Department of Primary Industries

OUT17/26949

Mixed Use Development, 50 Honeysuckle Drive, Newcastle (SSD 8019) Comment on the Environmental Impact Statement

BASEMENT GENERAL ARRANGEMENT PLAN - (ZONE 1)

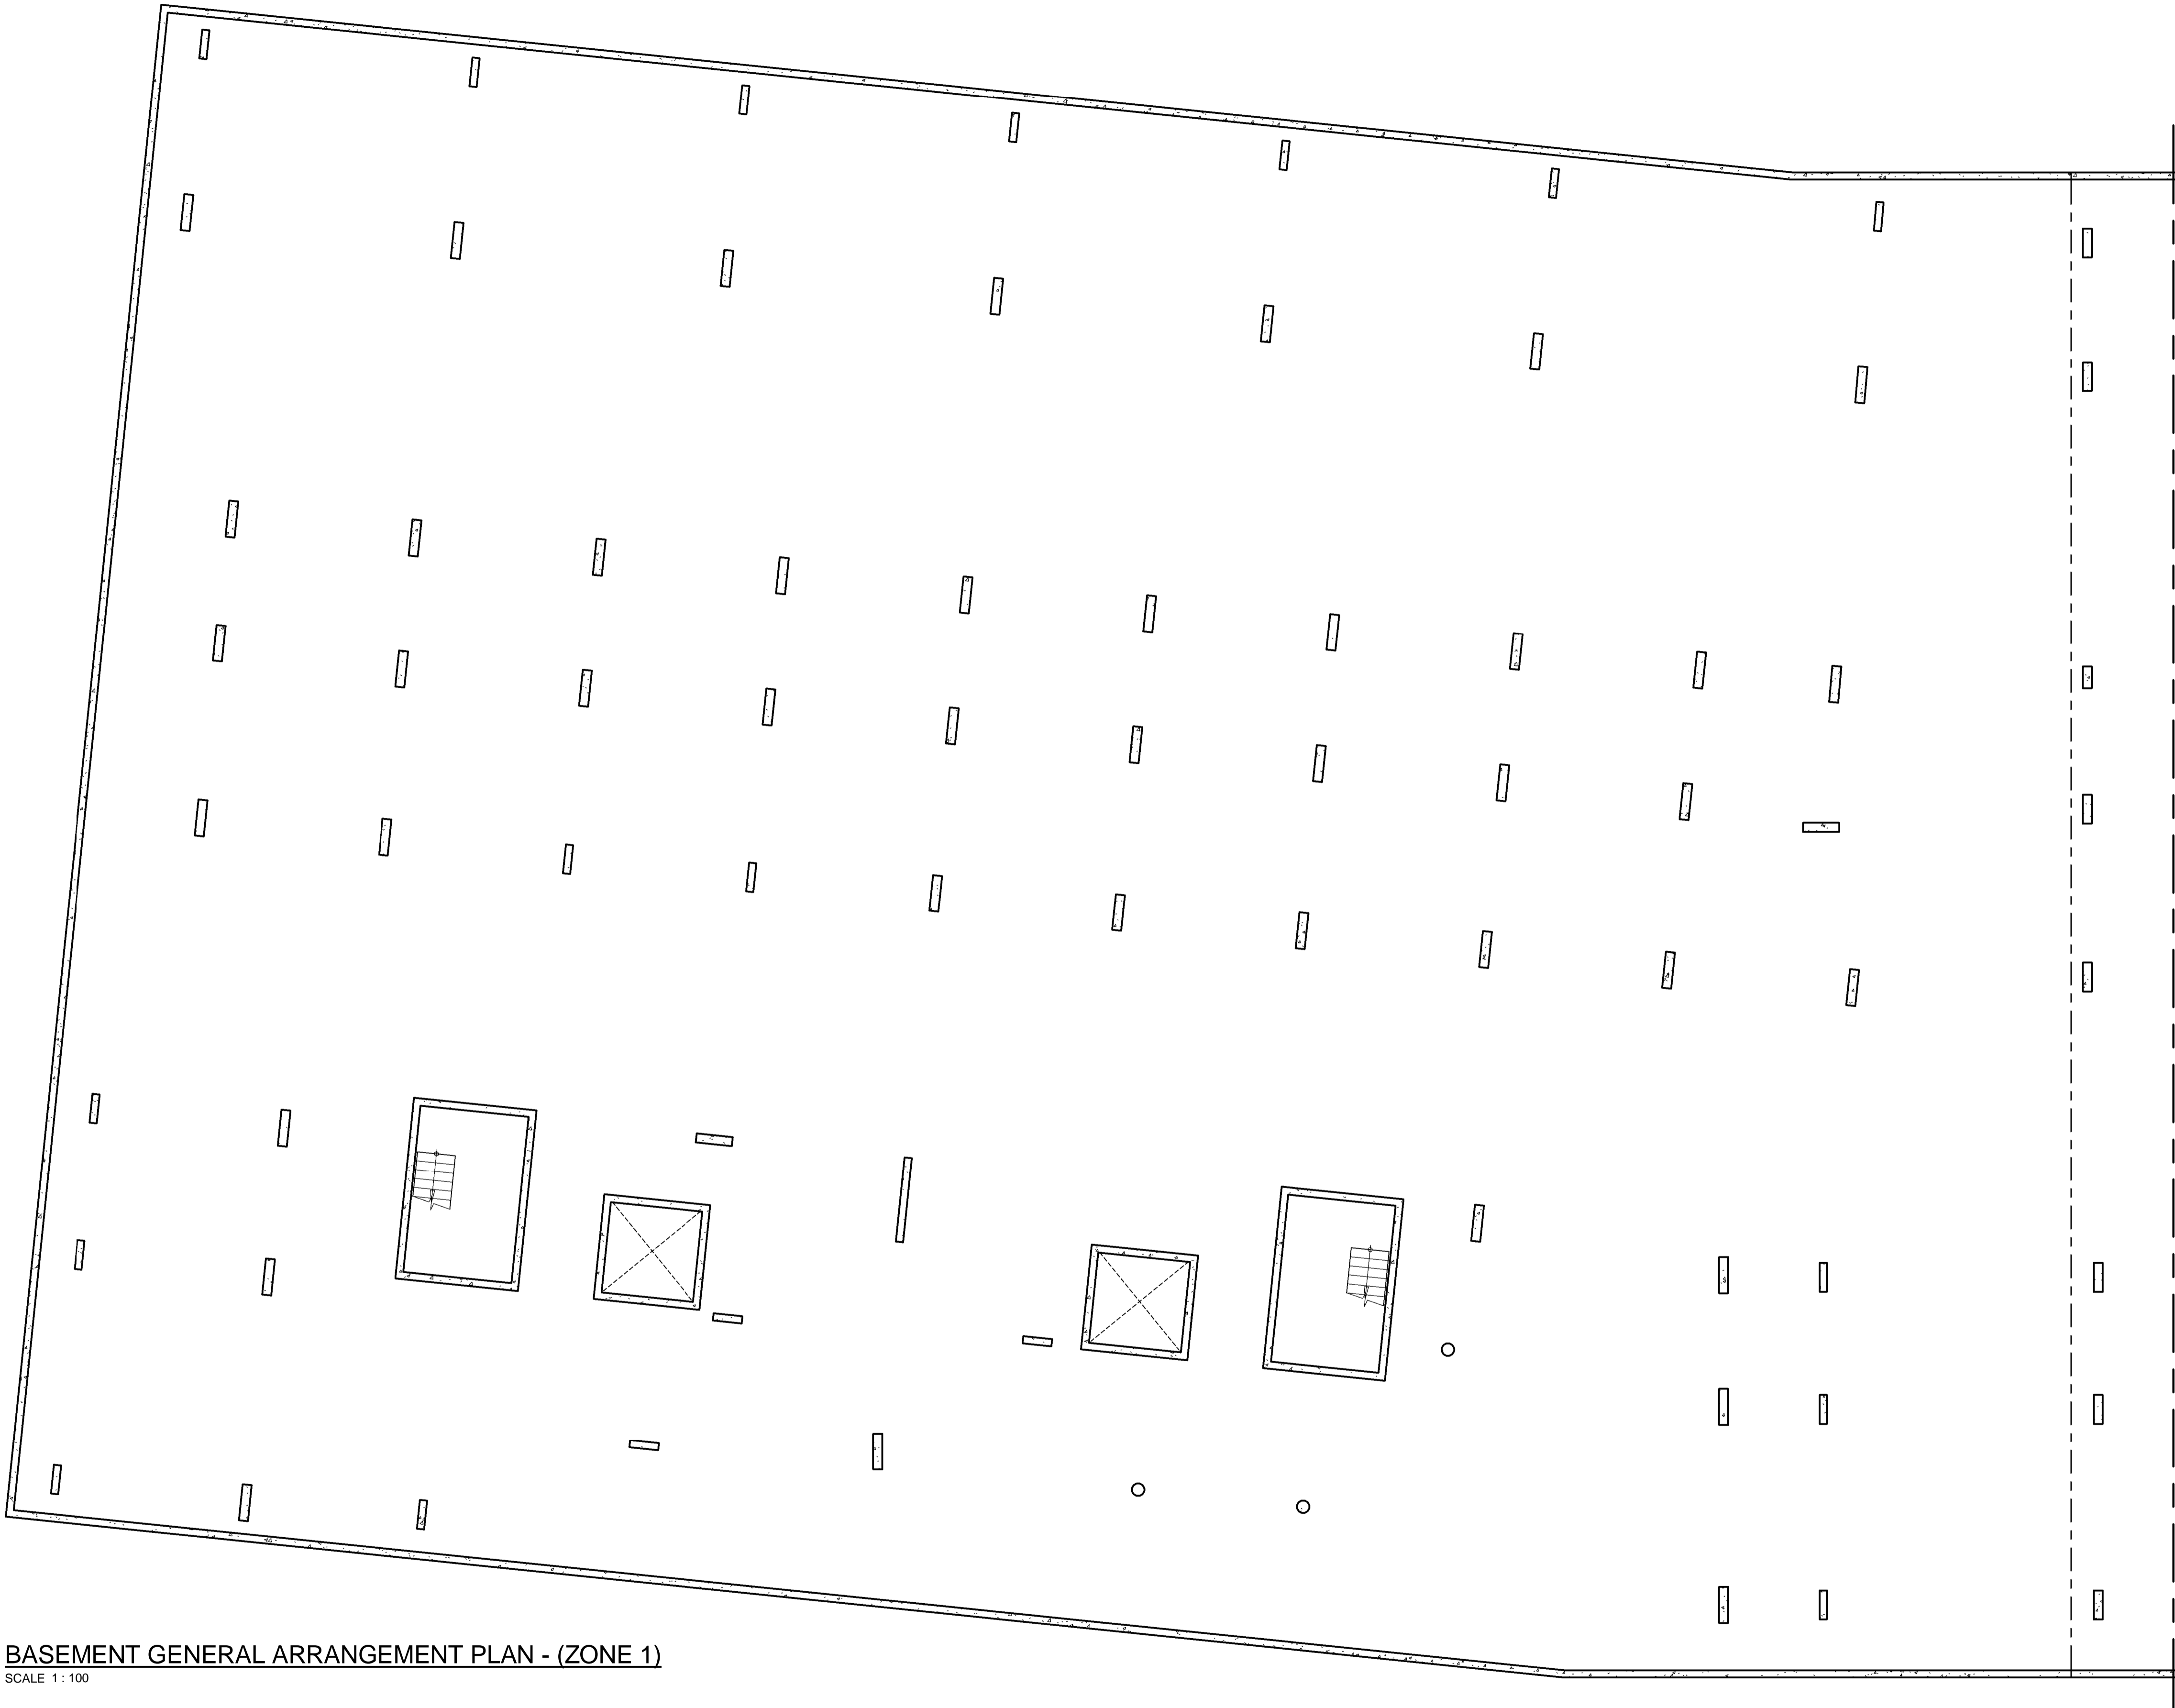
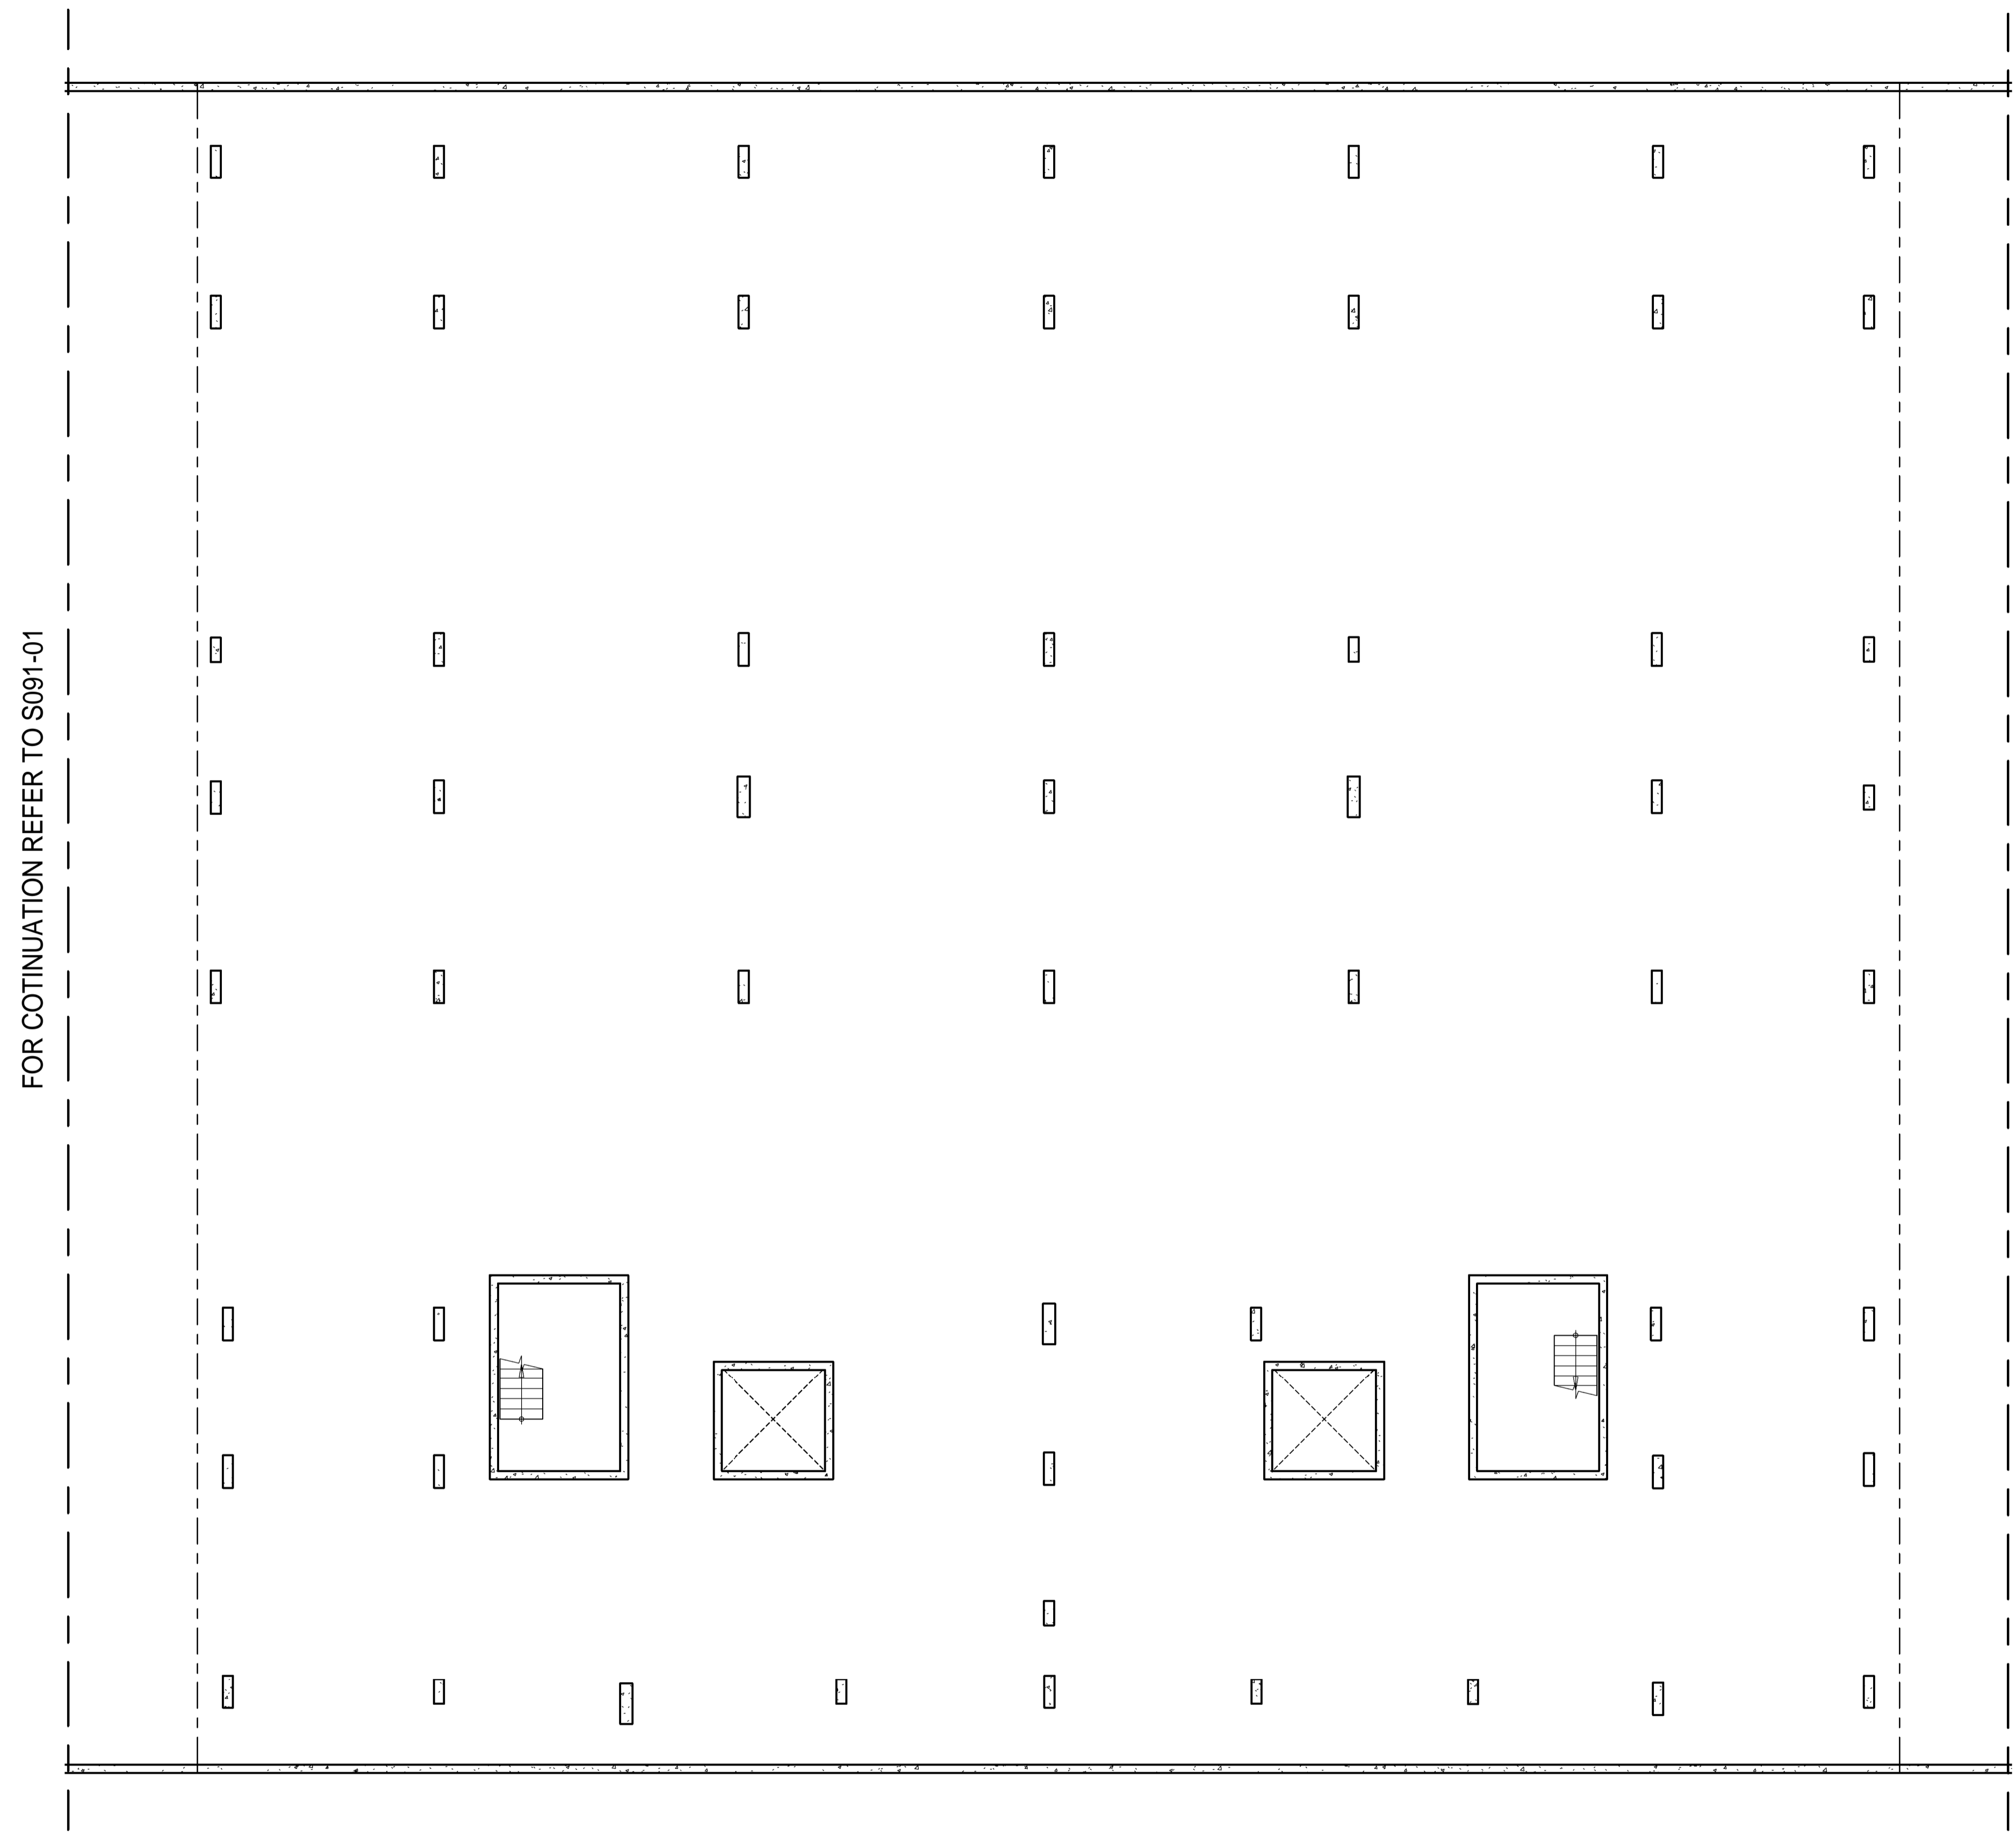
DPI does not consider that the SEARs have been adequately addressed as the extraction requirements of the construction dewatering have not been defined and there has been no assessment of the 'minimal impact considerations' of the NSW Aquifer Interference Policy (2012) (*the AIP*).

It is recommended that the proponent undertakes the above work and also provides the calculations used in estimating construction dewatering requirements. This is also important to ensure the waste water management plan is designed to ensure appropriate storage is available for extracted groundwater for retention times to facilitate optimal treatment of water quality prior

Further clarification is required regarding the proposed design of the basement carpark. DPI recommends the basement carpark be tanked (sealed) to prevent groundwater ingress. Any ongoing dewatering of the basement carpark will likely require a Water Access Licence from the Hawkesbury to Hunter Coastal Sands Groundwater Source.
